PLANNING AMENDMENT

Application No. **H08/0076/95**

DEMOLISH REMAINS OF FIRE DAMAGED GARAGE & REBUILD IN MATCHING STYLE & MATERIALS.

AMEND ENTRY DOOR & OUT 'TURN' WALL FIVE' & SUBSTITUTE BRICK ALTERNATIVE & RE-ARRANGE OIL STORE / STORE LAYOUT.

CONCRETE EXTERNAL WALLS TO THE THICKNESSES AS ILLUSTRATED Laid TO THE SAME BOND AS THE EXISTING WALLS & POINTED IN CONCRETE SAND LIME MORTAR 1:1:6 WITH FLUSH FINISH.

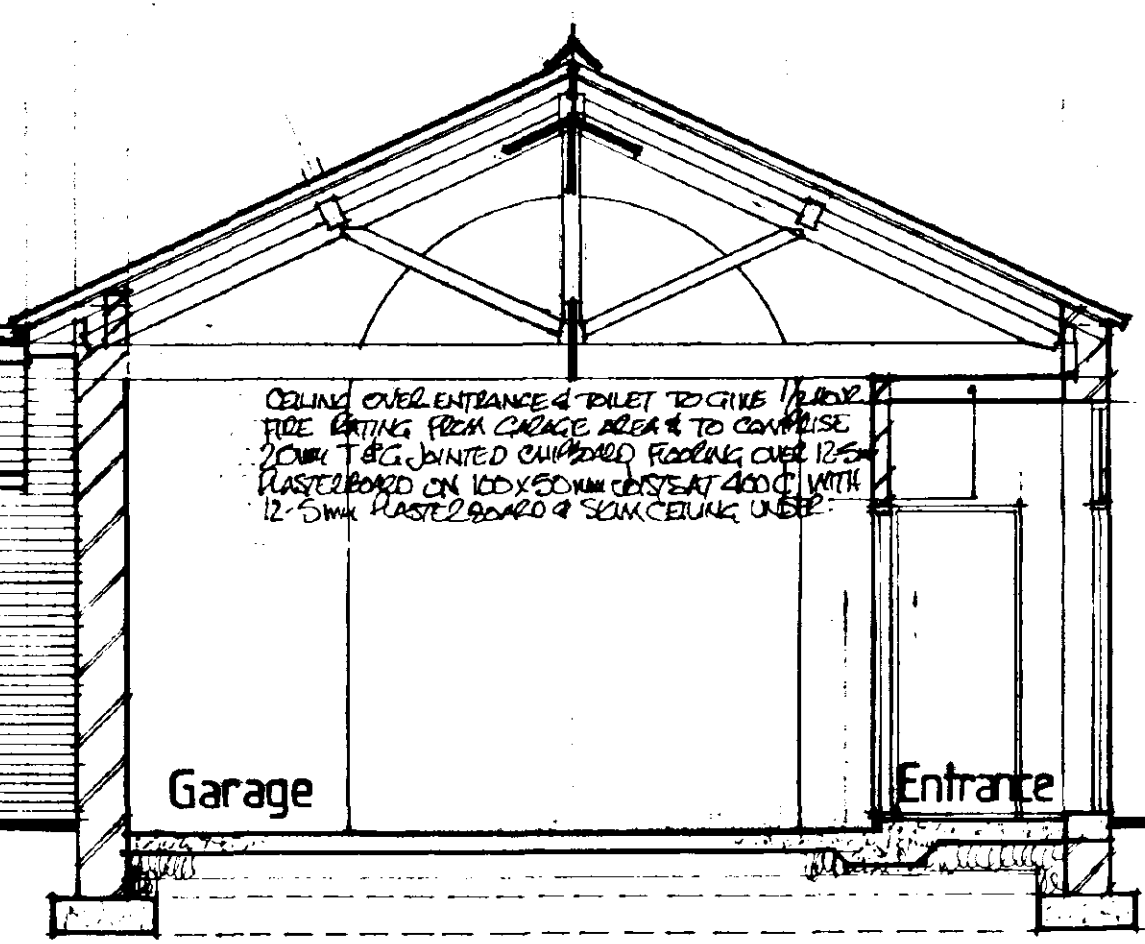
Amendment Submitted: Amendments to entry door, "Twin Wall" flue and oil sto
Drawing No. 94:40:2A.

Amend entry door in East Elevation.
Insert window^{+door} in West Elevation.
Substitute Pine with brick chimney.
Rearrange internal layout.
